**Our Ref: LU/89/13/
Your Ref:**

Application for Planning Permission for Works or Extension to a Dwelling

Development Single storey extension to rear of property.

Location 10 West Head Littlehampton

Drawing Title :-
**PROPOSED
 FLOOR PLAN**

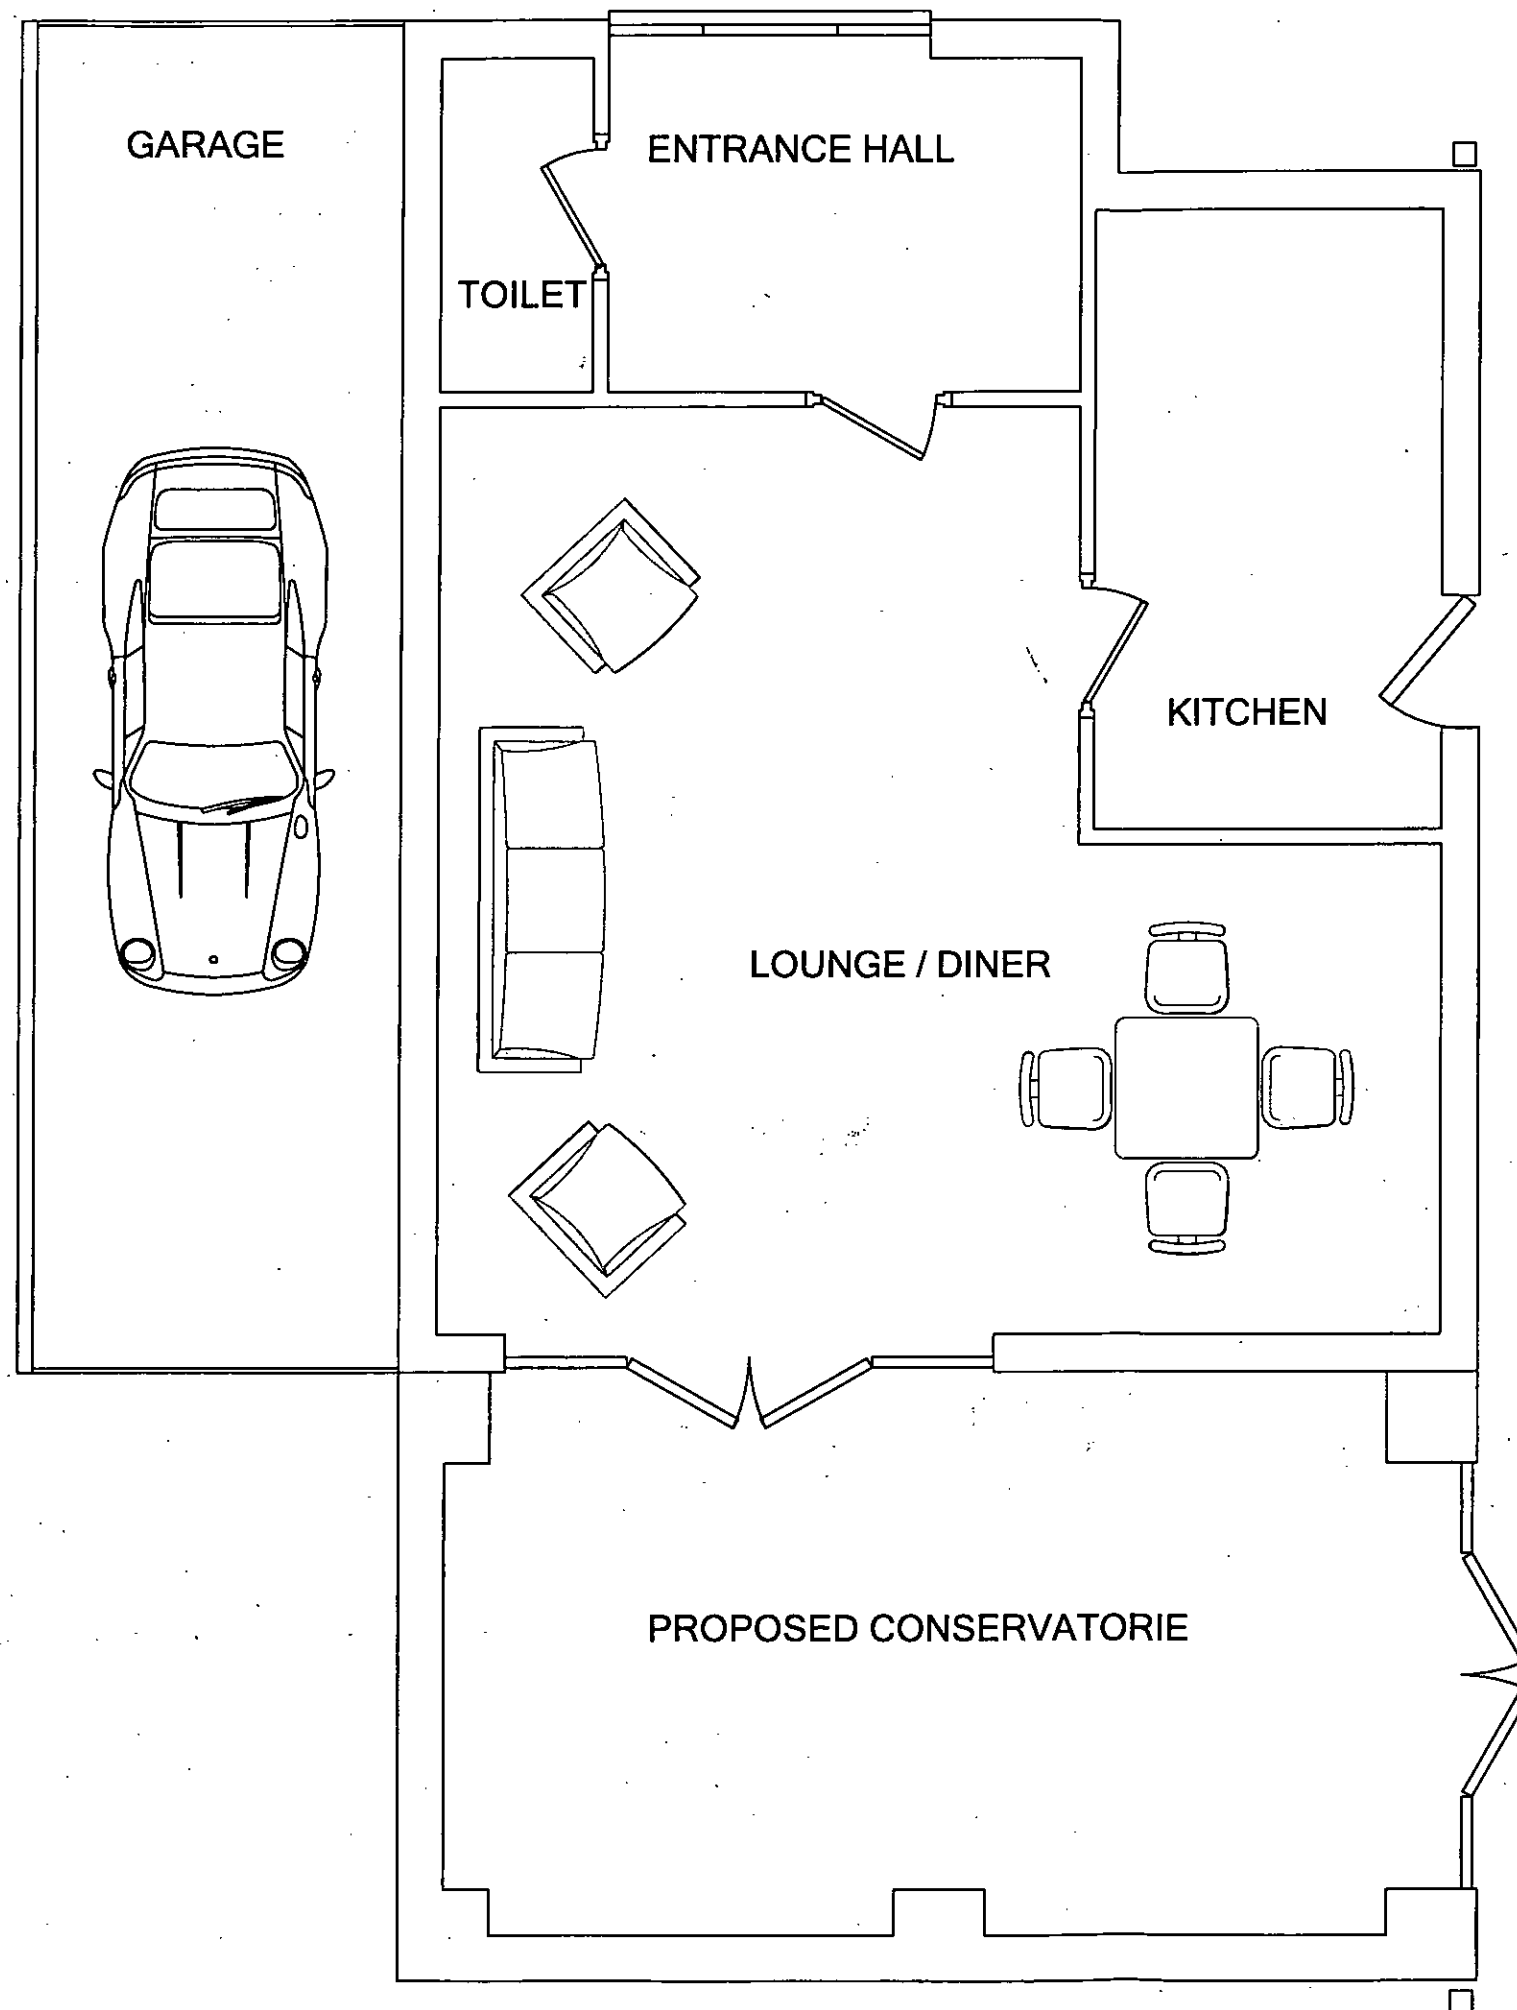
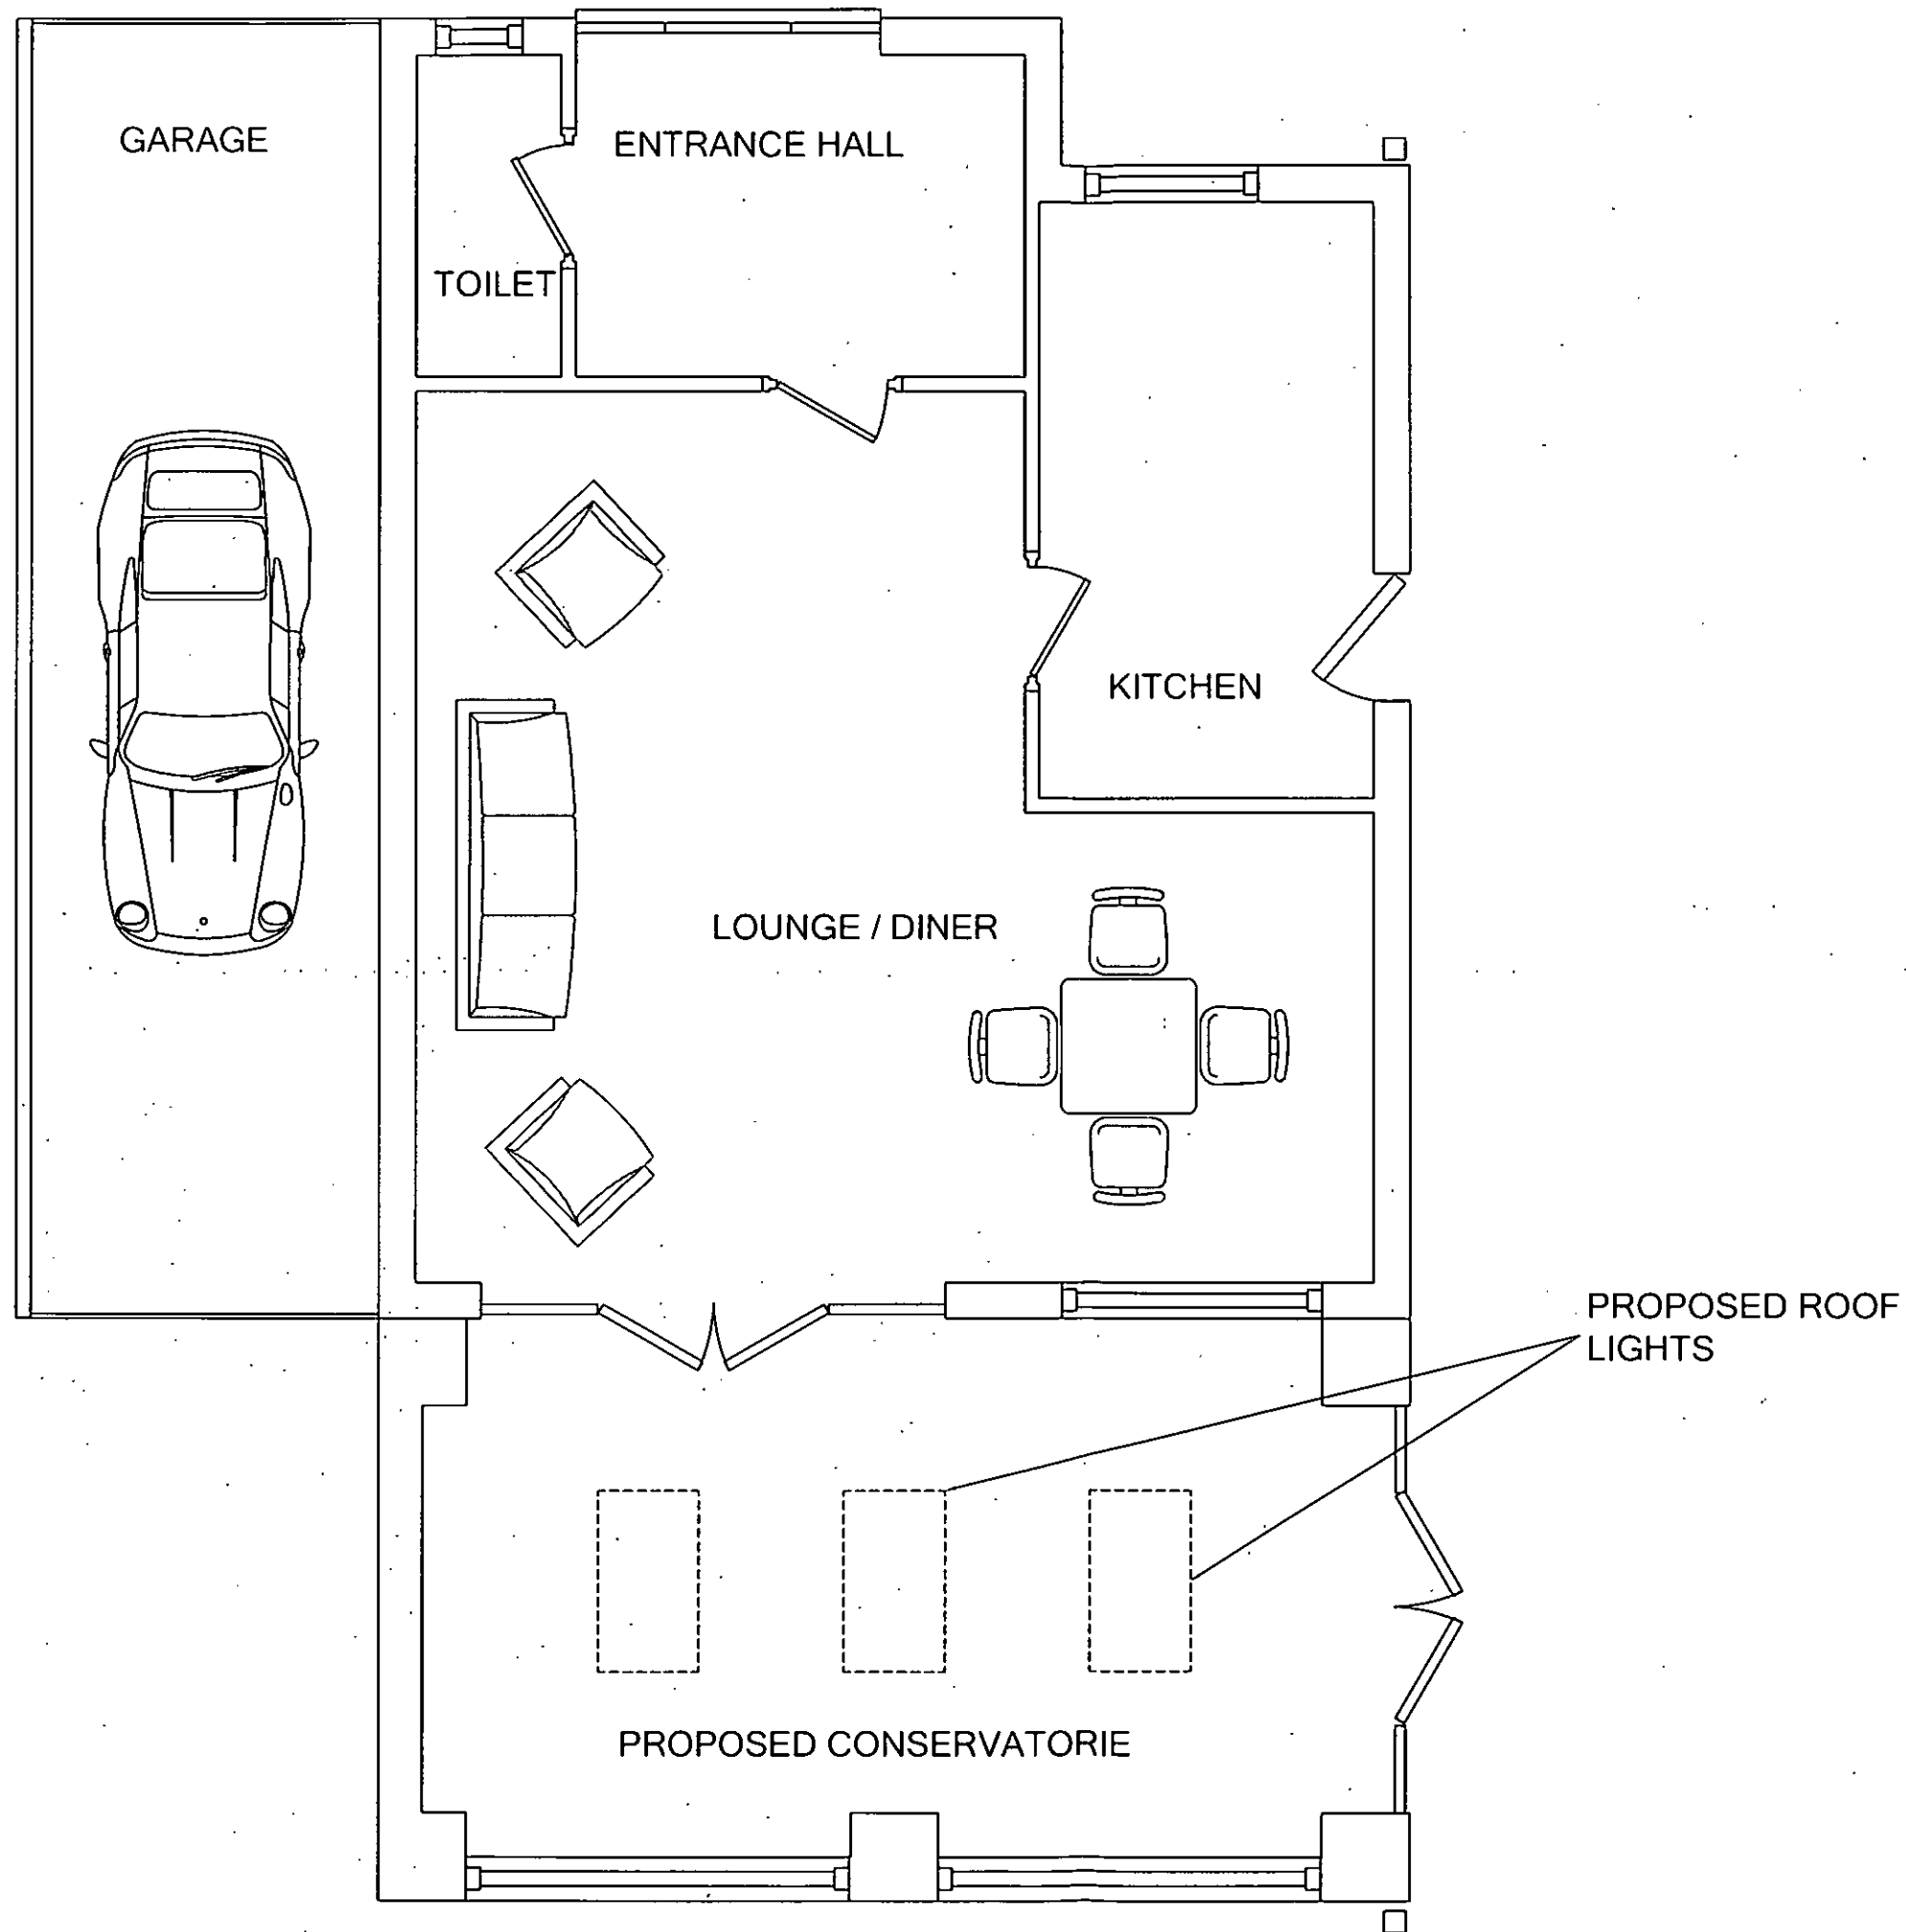
Please forward amended floor plans to clearly show all openings (windows & velux)
